Ribble Valley Borough Council
Housing & Development Control

Application no: **3/2022/0666**

Address: **49 Dale View Billington BB7 9LL**

Proposal: **Proposed conversion of the existing loft void with the addition of a rear dormer roof window. Conversion of existing garage into residential accommodation with single storey side extension. Widening of existing drive.**

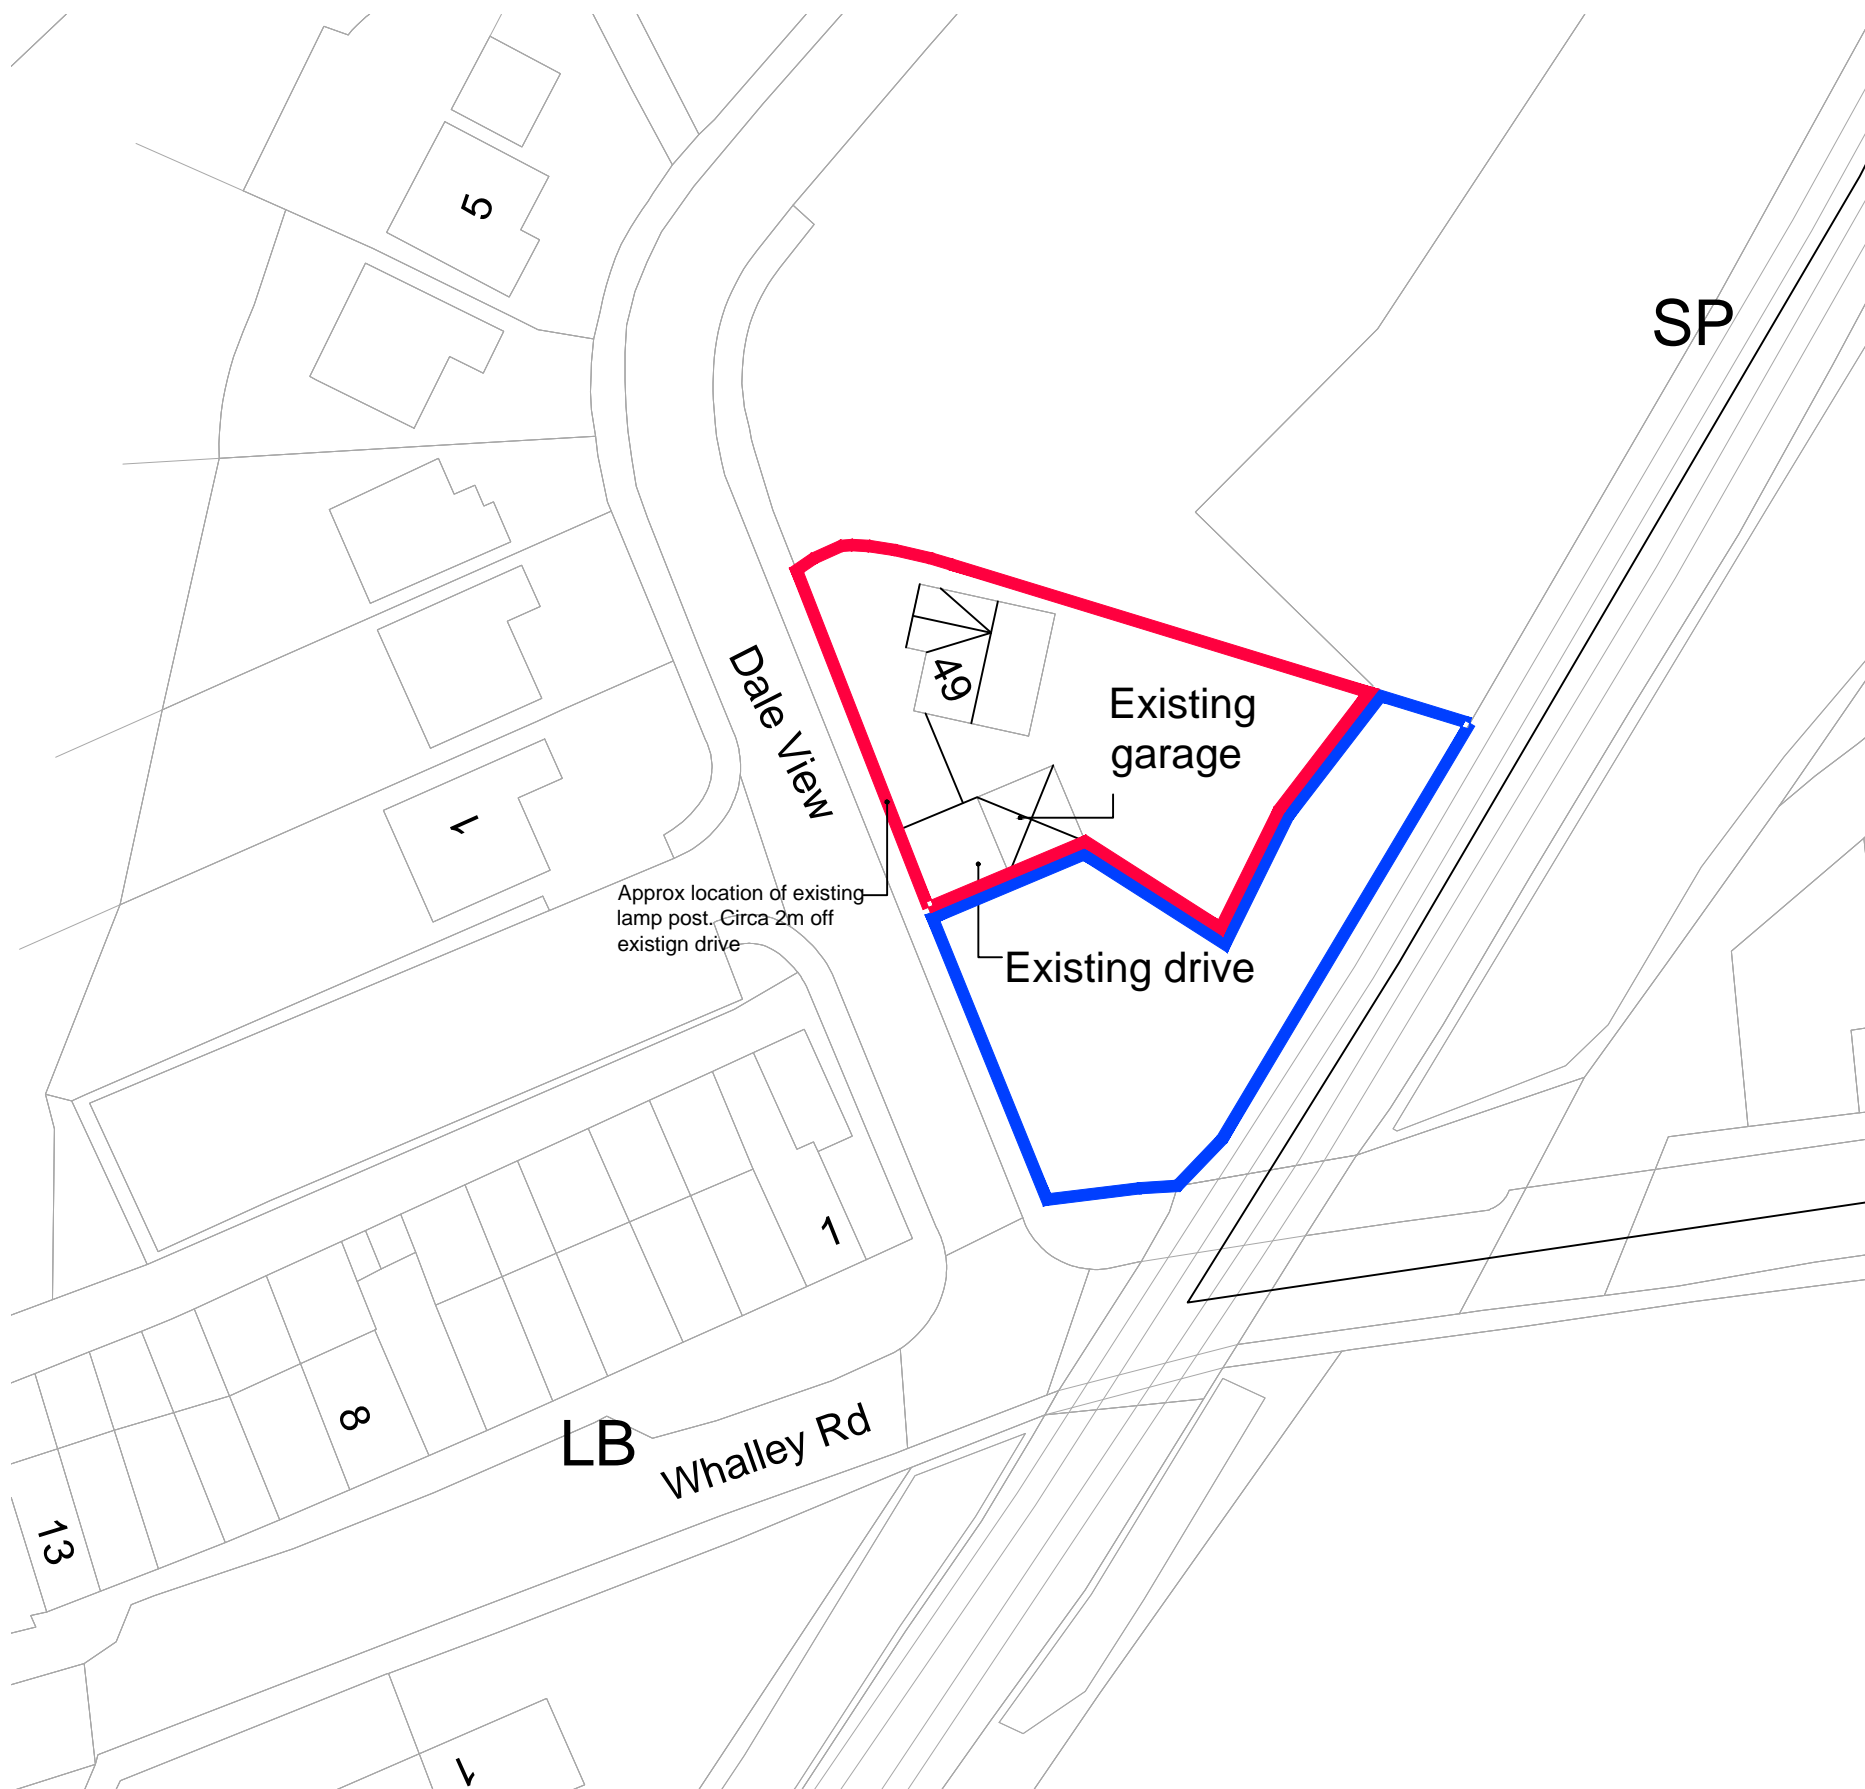
The LHA have reviewed drawing number 49DaleView/Planning/04 Rev B titled "Existing and Proposed Site/Location Plan" and are aware that the widening of the driveway will allow at least 3 car parking spaces to be provided which complies with the LHAs parking guidance for a 4+ bed dwelling.

The LHA are aware that the streetlight, as shown on the plan, is 2m away from the proposed extension to the access. However, should this change on the ground following works to the site, the LHA makes the Applicant aware that they will be liable to the full cost of relocating the streetlight elsewhere.

1. No part of the development hereby permitted shall be occupied until such time as the access arrangements shown on drawing number 49DaleView/Planning/04 Rev B have been implemented in full.

2. The development hereby permitted shall not be occupied until such time as the parking and turning facilities have been implemented in accordance with drawing number 49DaleView/Planning/04 Rev B. Thereafter the onsite parking provision shall be so maintained in perpetuity.

3. The development hereby permitted shall not be occupied until such time as the access drive (and any turning space) has been surfaced with tarmacadam, or similar hard bound material (not loose aggregate) for a distance of at least 5 metres behind the highway boundary and, once provided, shall be so maintained in perpetuity.

4. The surface water from the approved driveway should be collected within the site and drained to a suitable internal outfall. Prior to commencement of the development
